from
**Southern
Water**

Our ref
PLAN-034392

Proposal: Approval of details reserved by condition imposed under ref A/51/14/OUT relating to Condition Nos 19 - foul water sewerage disposal and 20 - public water supply main.

Site: A/86/20/DOC: - Manor Nursery, High Street, Angmering, BN16 4AW.

TITLE Site Layout
Southern Water Asset Constraints

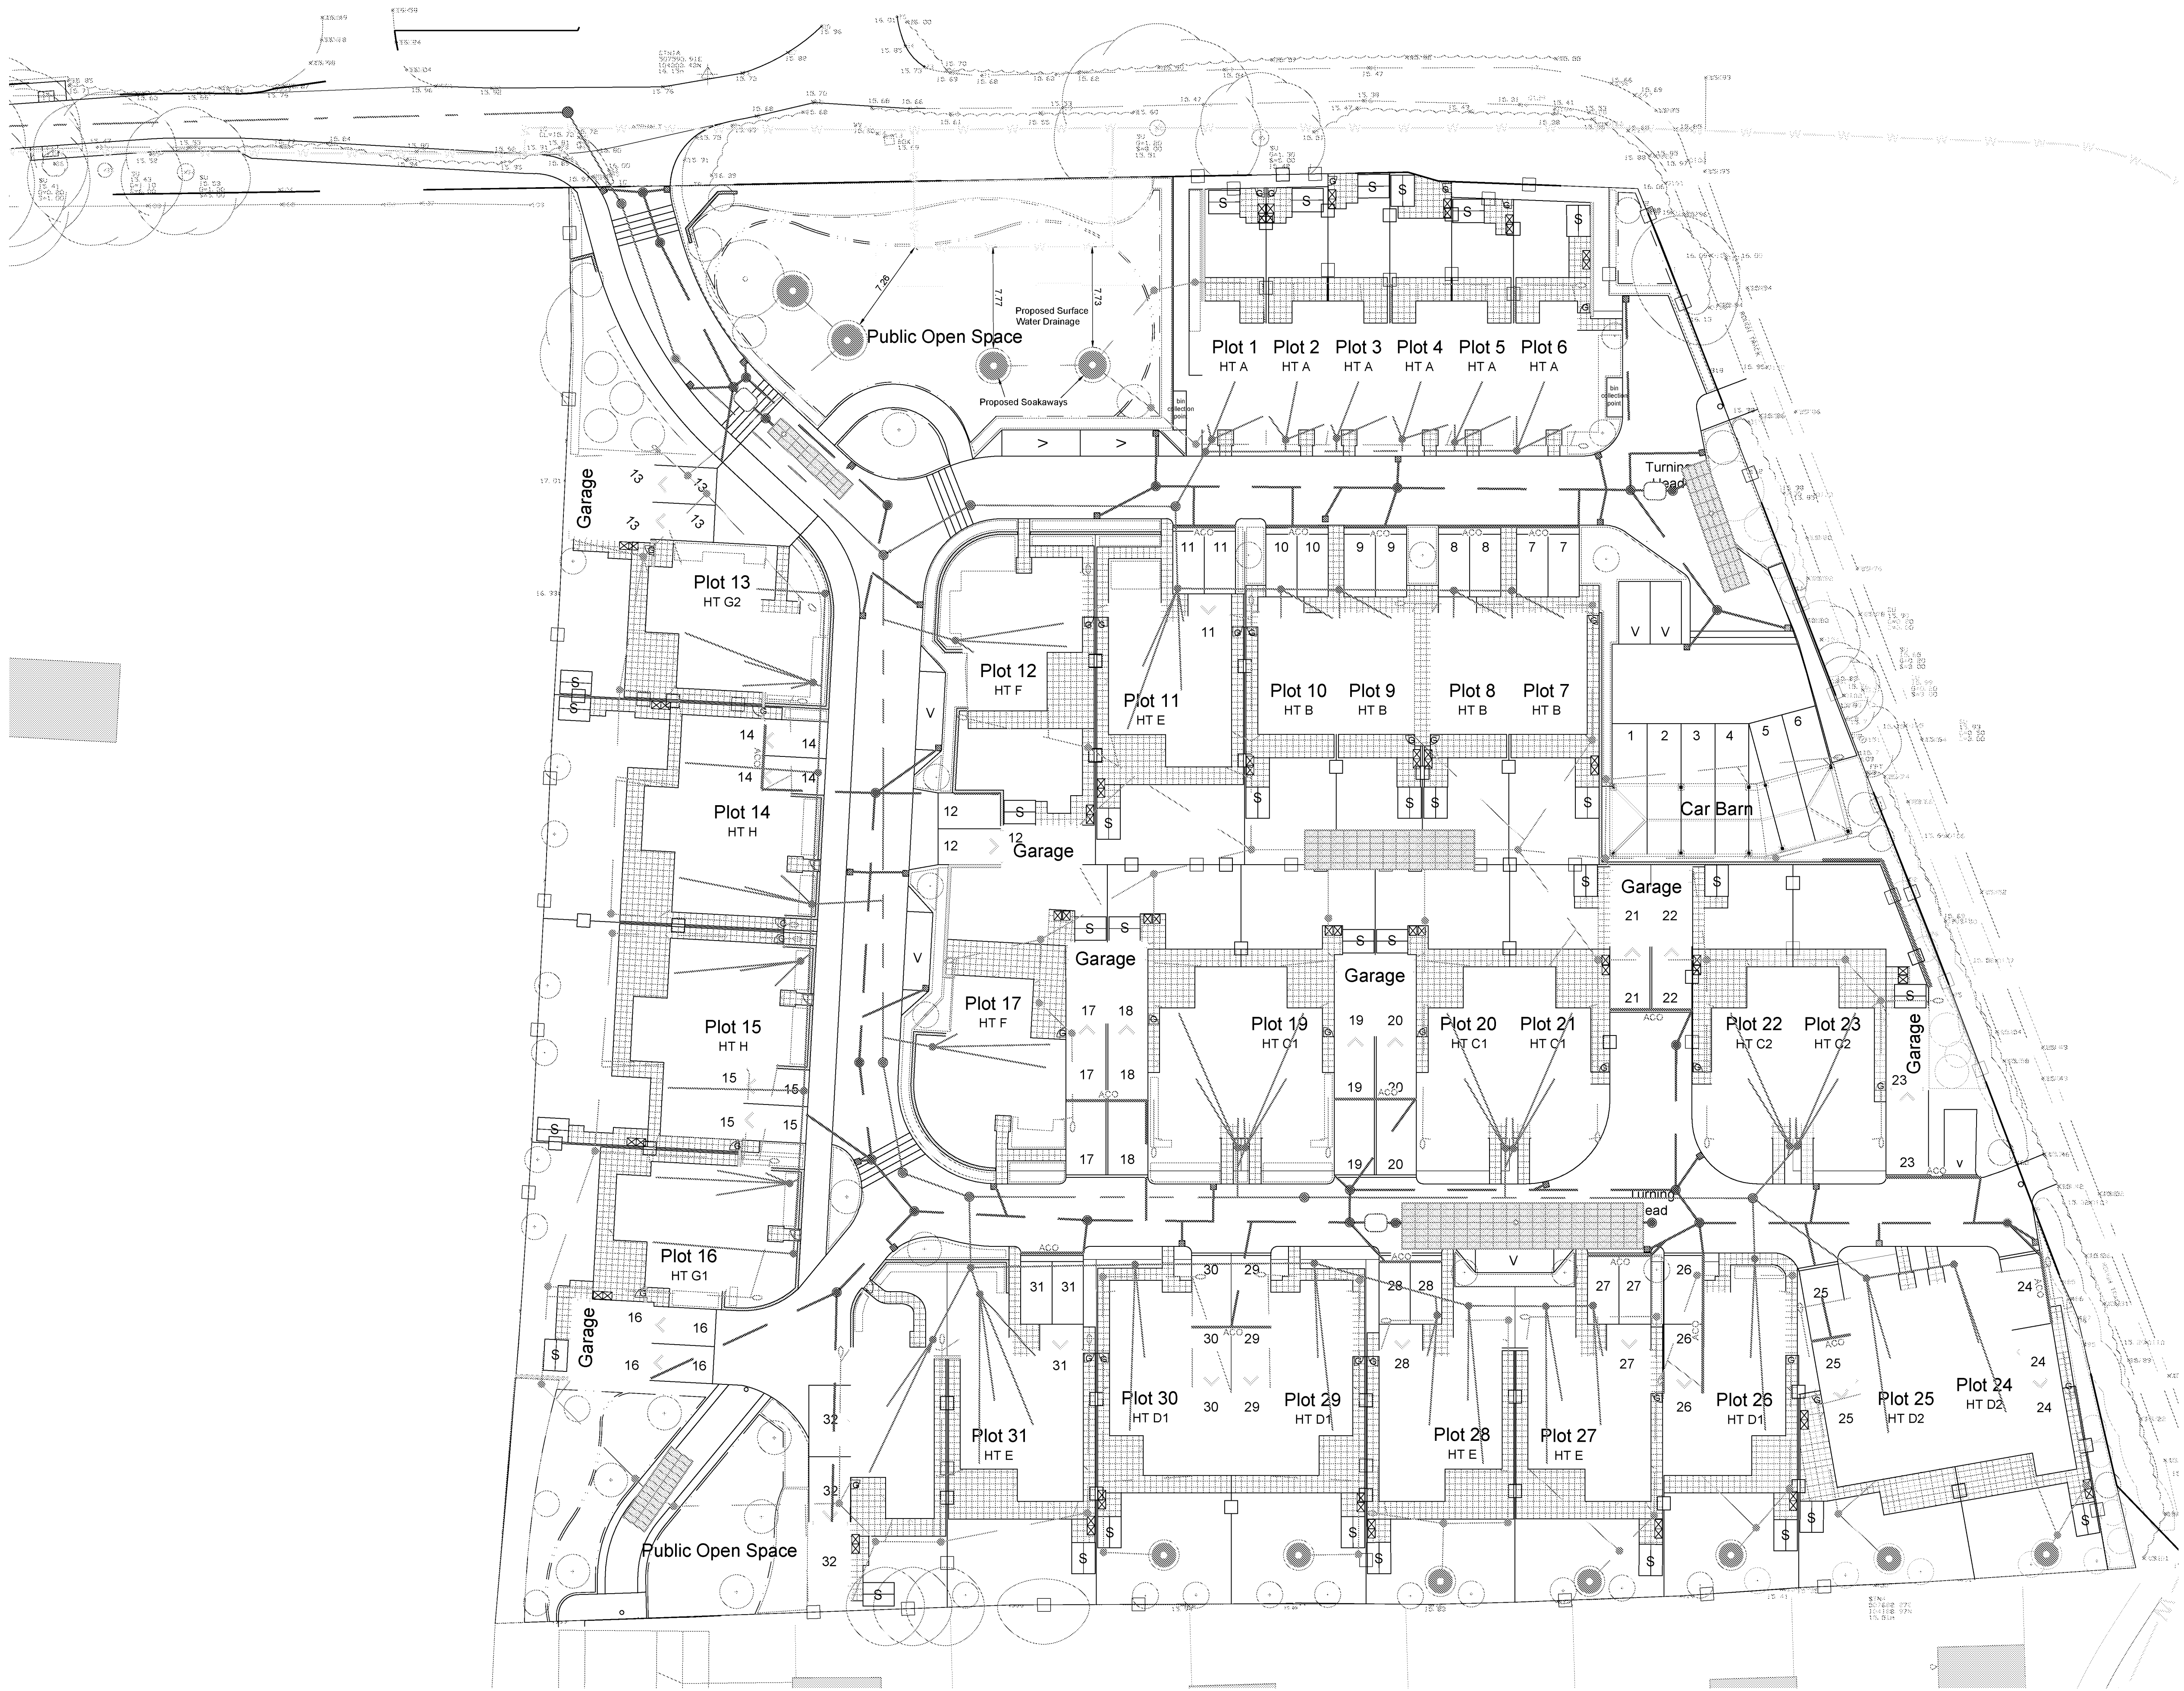
Southern Water cannot recommend discharge of condition 20 relating to protection of public water supply main. The submitted plans do not show any protection measures (easement) for the water mains.

No development, excavation, mounding or tree planting should be carried out within 6 metres of the external edge of the public water main without consent from Southern Water.

Also, the proposed soakaways are located within the standoff distance of public water main.

A realignment will be needed to the soakaway position to create a greater clearance between the soakaway and public water main.

No soakaways, swales, ponds, watercourses or any other surface water retaining or conveying features should be located within 5 metres of public water main.

The drainage proposals shall include protection measures to be shown to satisfy the requirement to maintain standoff distances for public water mains.
